TfNSW Reference: SYD21/00456/02 & Departments Reference: SSD-17552047

**EXHIBITION OF EIS – ALDINGTON ROAD ESTATE - 155-217 ALDINGTON ROAD -
KEMPS CREEK**

Attachment A

TYPICAL SECTION - PROPOSED ROAD 2 (24.00m)  
 (MC02)  
 SCALE 1:50

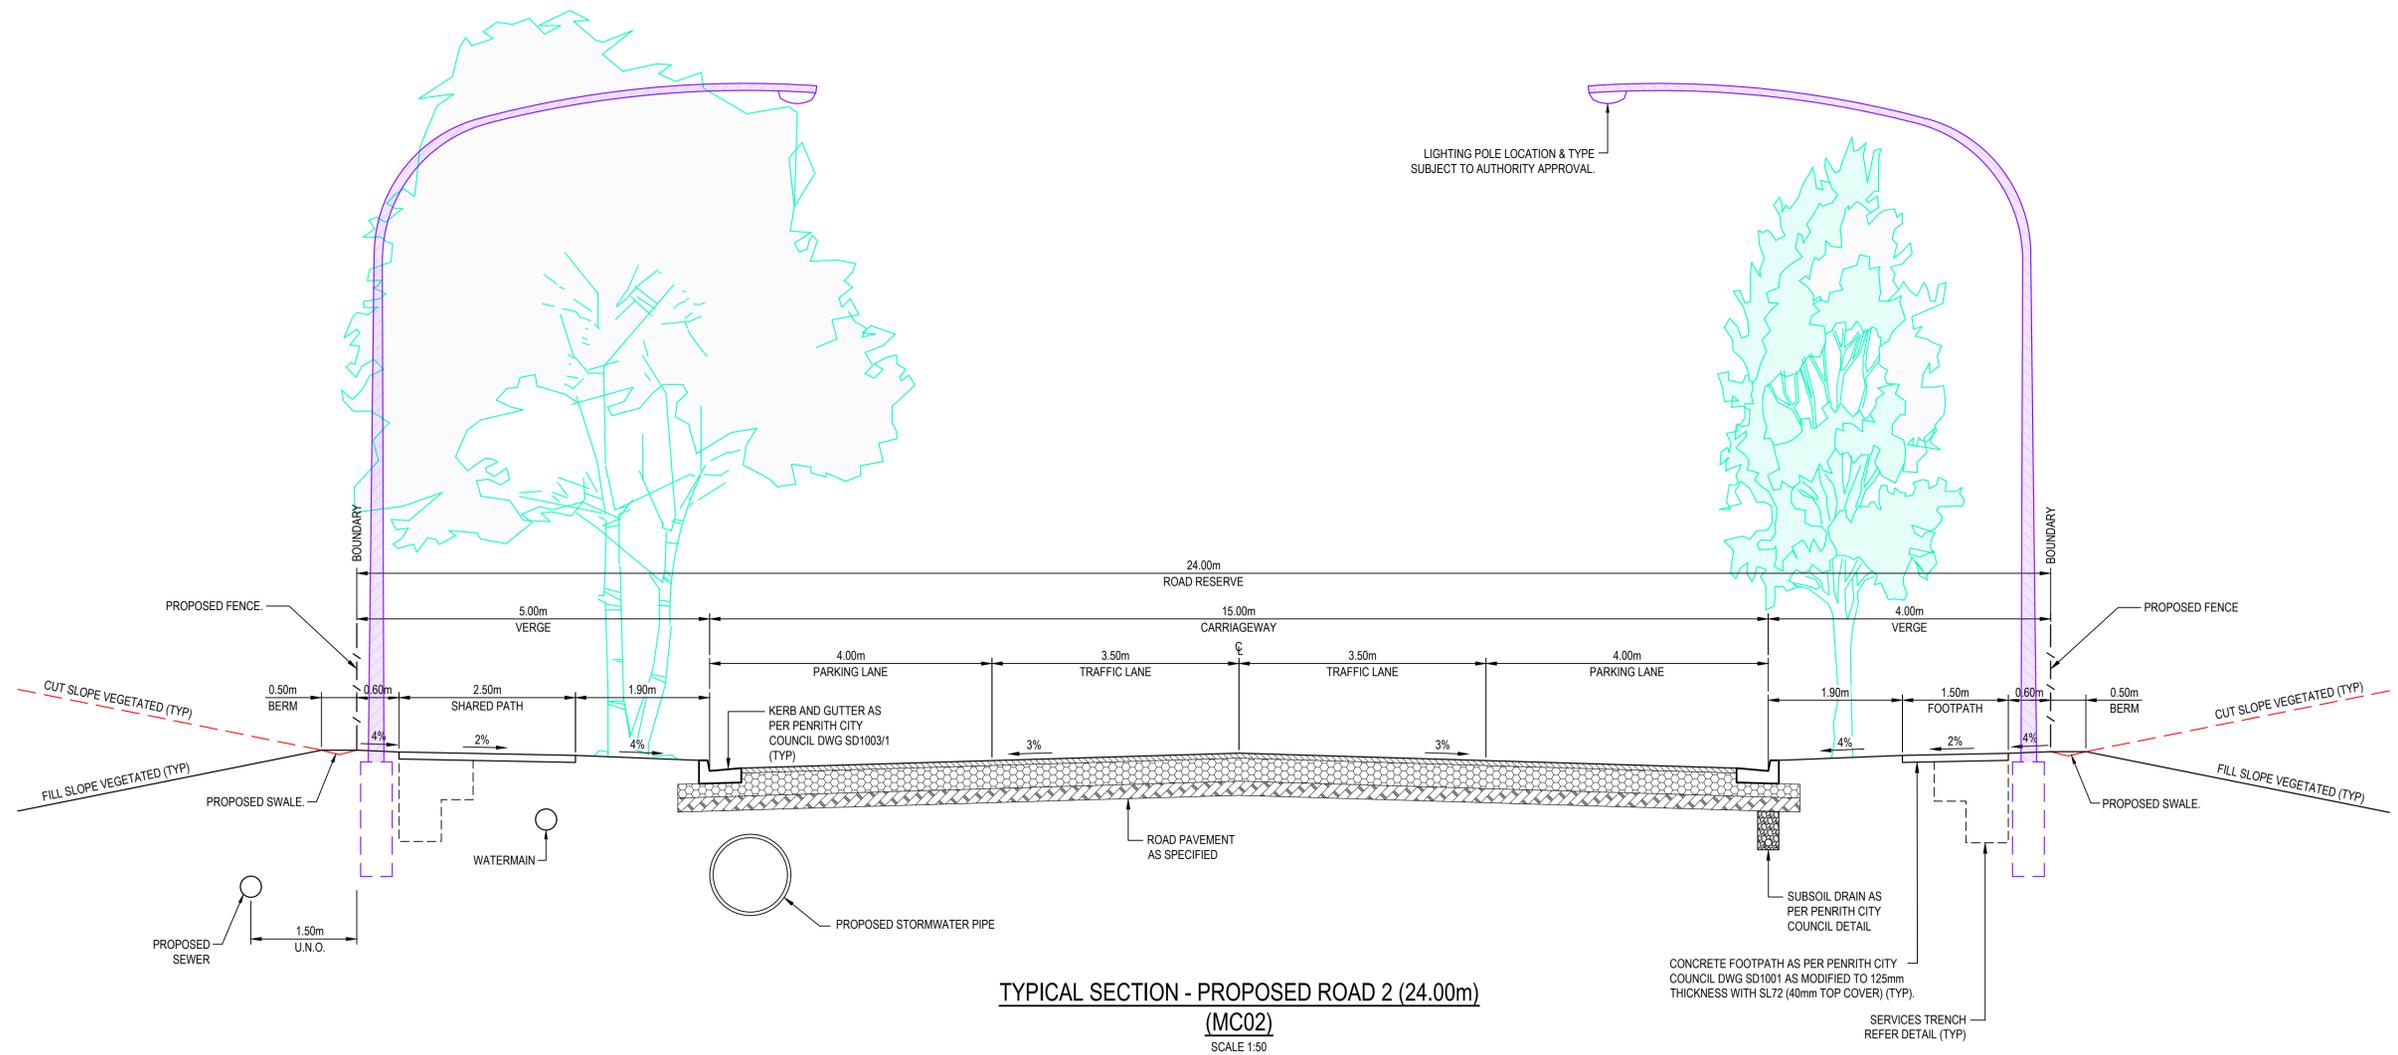
Mamre Road Precinct DCP Table 9. Provides a summary of the preferred road typology. The summary includes road reserve widths for different road types. *Frasers Property* subdivision plan road reserve widths appear narrower than that required by the cross-sections for a typical distributor road (Aldington Road) and a collector road.

Figure 12 of the DCP indicates that the road network hierarchy for the east west road should be a collector road. In addition the DCP indicates that the connection to Aldington Road is to be signalised. This would result in the need to provide a central median and therefore the road reserve of 26.4 meters in width would be required.

A measurement was not provided for the width of Aldington Road however it appears that the widths are less than the required 30.6 metres for a distributor road.

The subdivision plan should be updated to reflect the Mamre Road Precinct DCP preferred road typologies.

TURN PATH 7  
36m B-TRIPLE RIGHT TURN ONLY

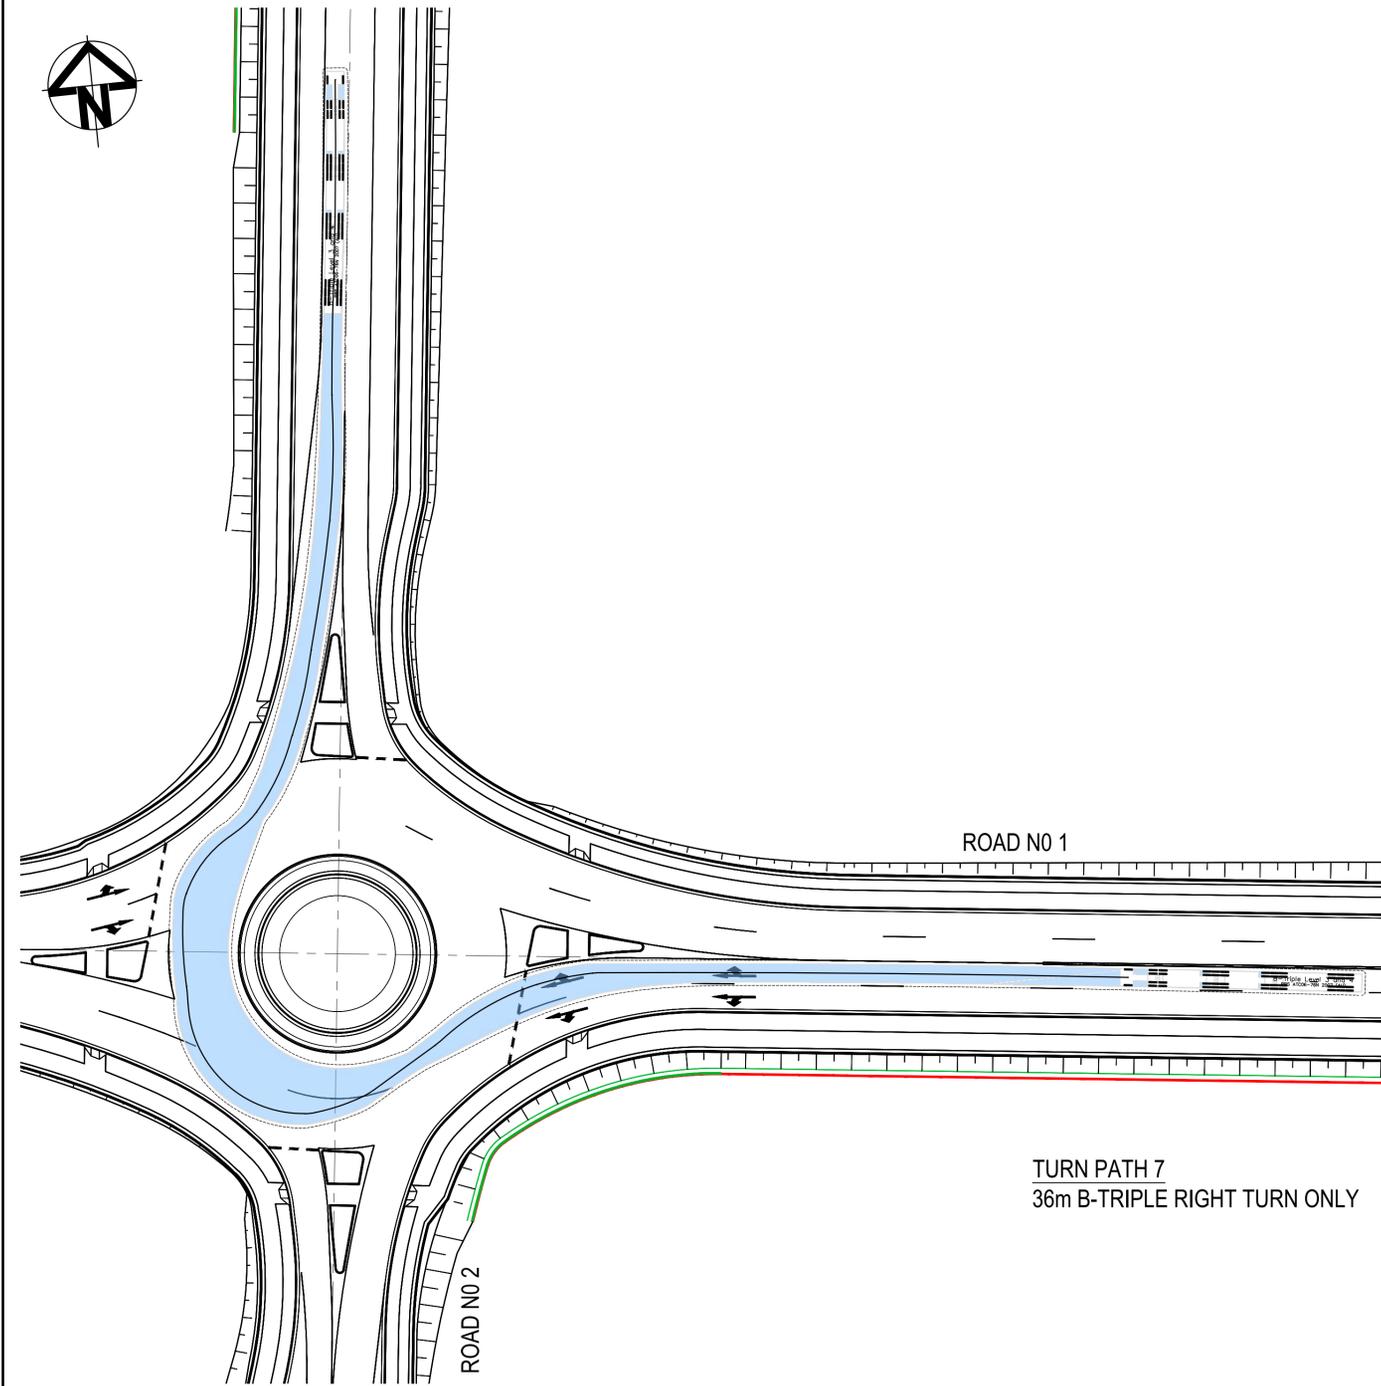
Appendix E – Swept Path - Turning path plans are provided for 30m A-Double. According to the Mamre Road Precinct DCP Road design item (20), it should be tested for 36.5m PBS Level 3 type A vehicles.

It is requested that Swept path plans be provided showing the test vehicle of a 36.5m PBS Level 3 type A vehicle.

DRAWING NUMBER ISSUE  
SP1-AE-DA-003 B

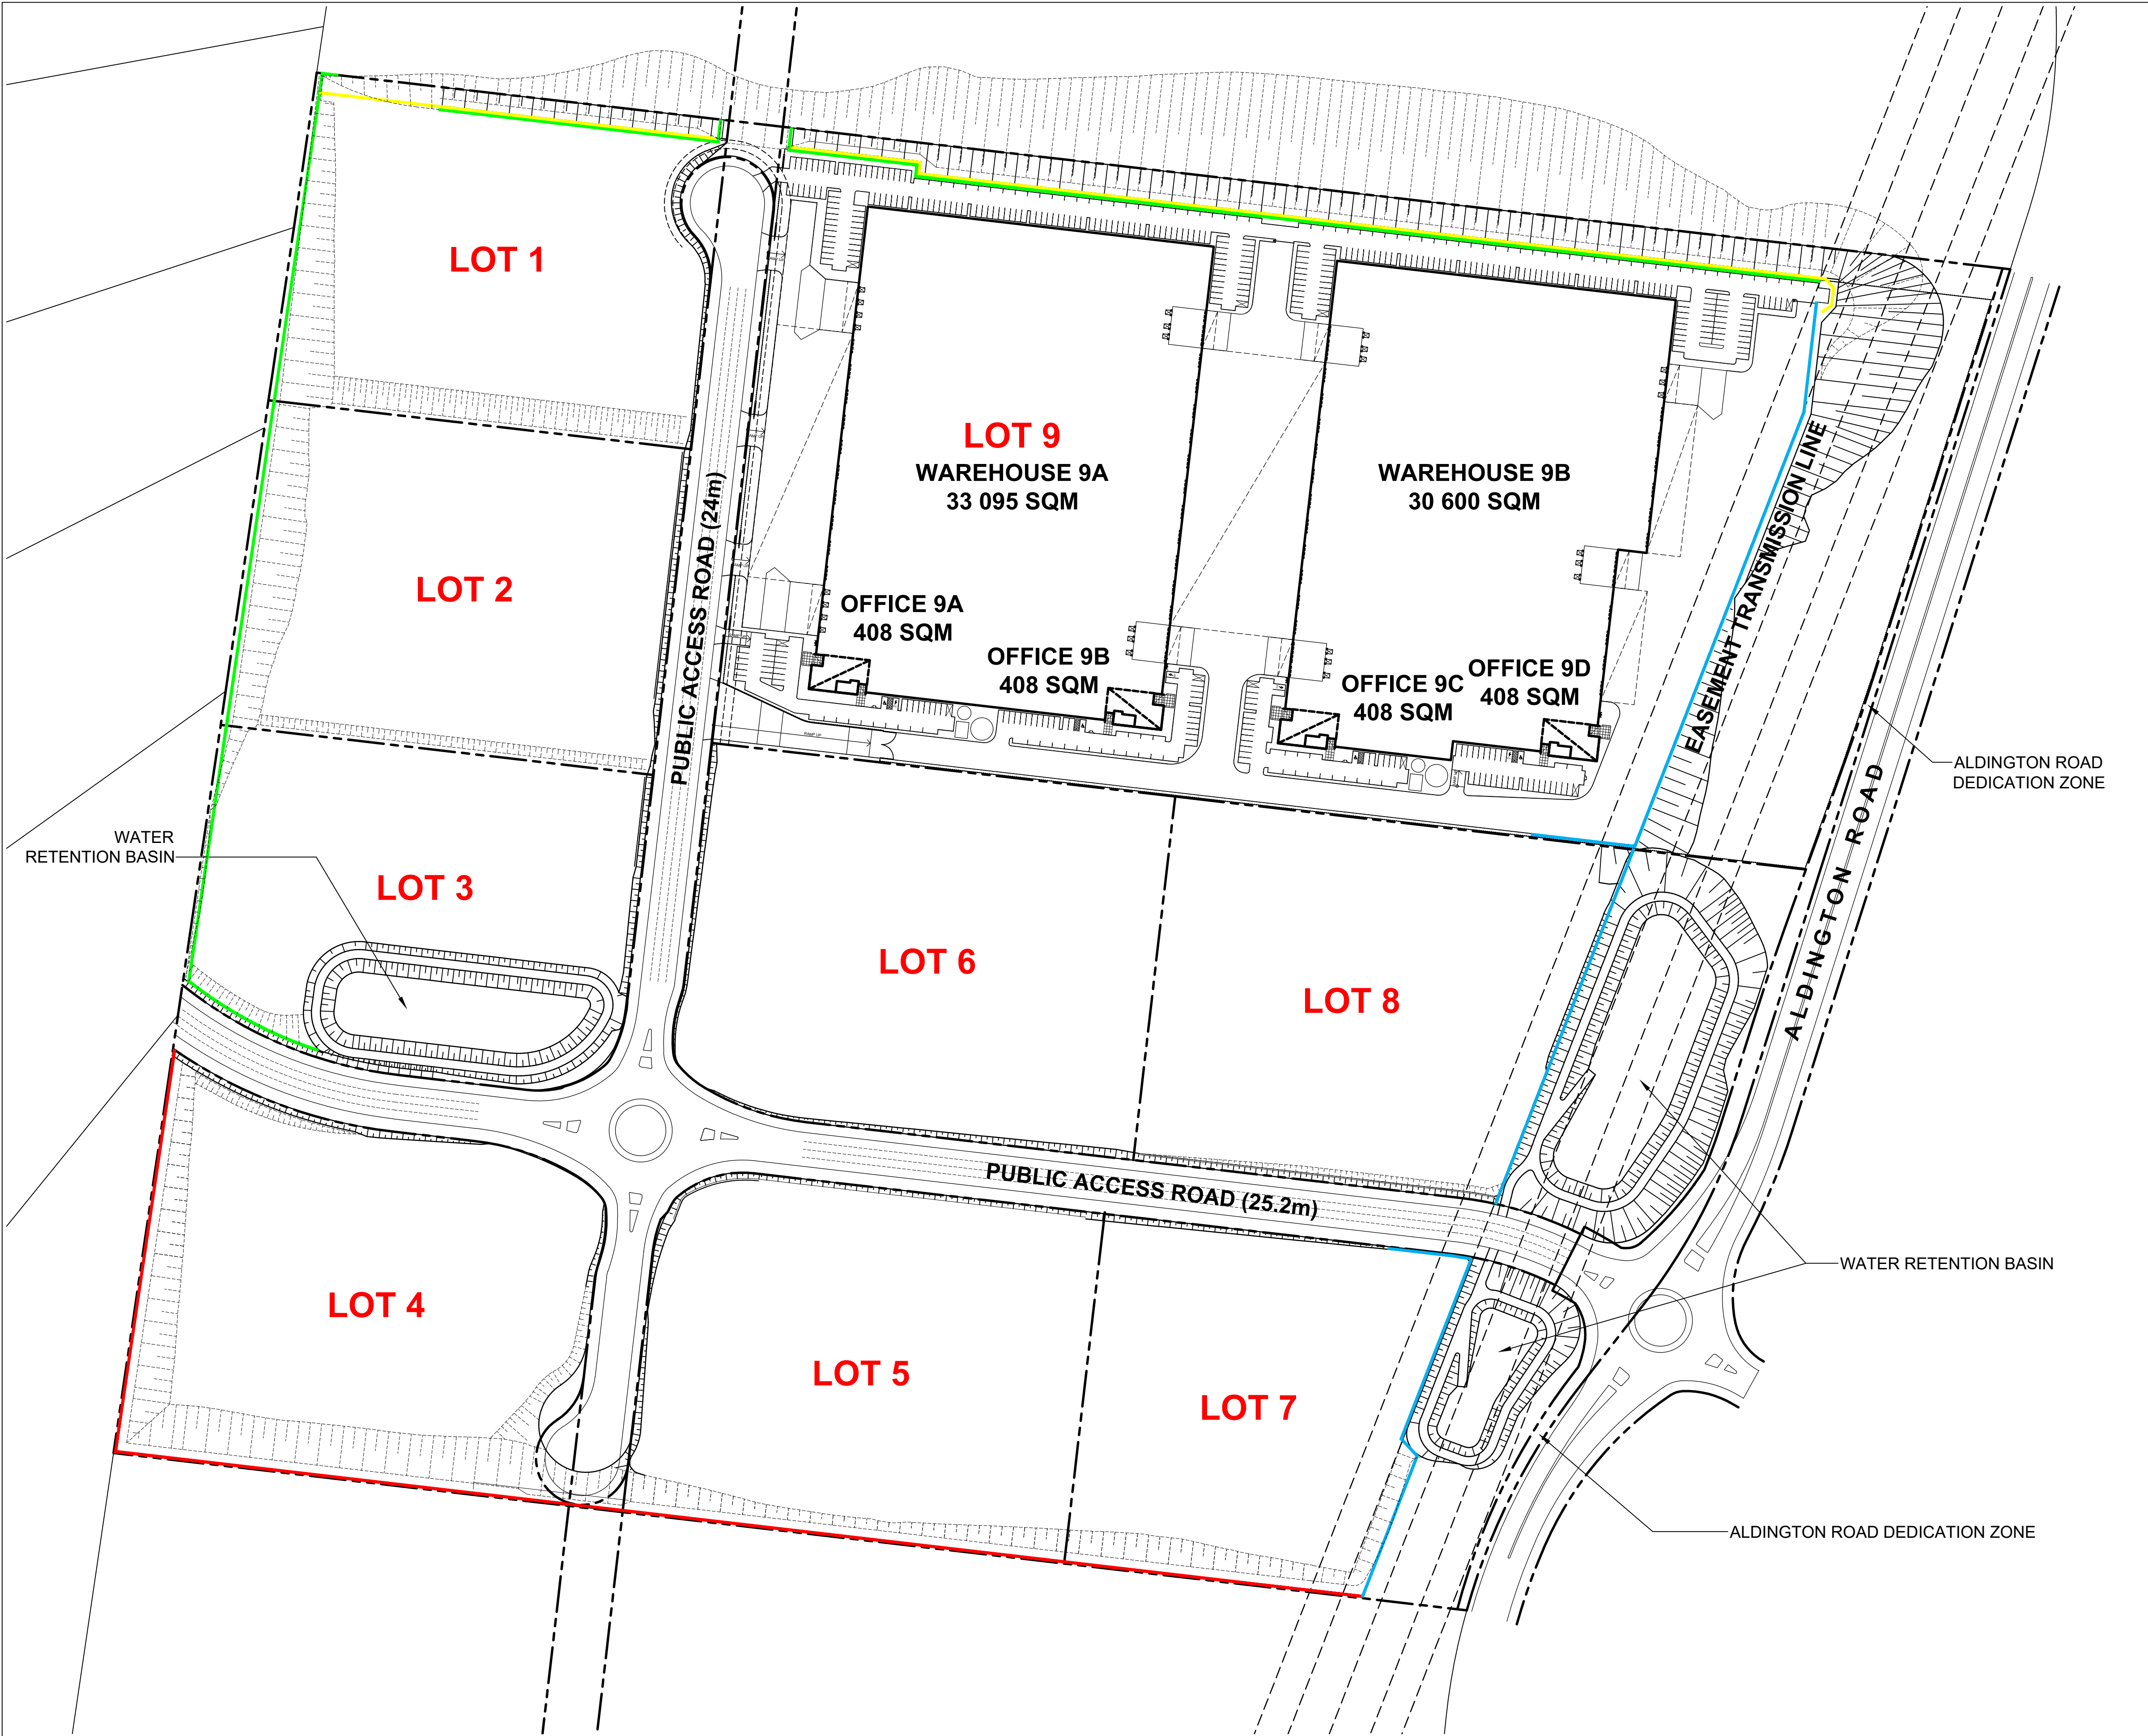
TfNSW notes that the notations on Drawing No. SP1-AE-DA-004 suggest the north-south internal road will be extended to accommodate surrounding development and that this is consistent with the provisions of the Mamre Road Precinct DCP.

Significant landform modification/ retaining works are proposed to the Northern portion of the site, it is unclear if these works impede capacity to extend the internal collector road to the north.

Further clarification should be provided to understand why the road is not being constructed to the development boundary and whether the proposed landform modification/ retaining works will impede capacity to extend the internal collector road to the north. There may be implications to the broader road network should this connection not be able to be achieved.
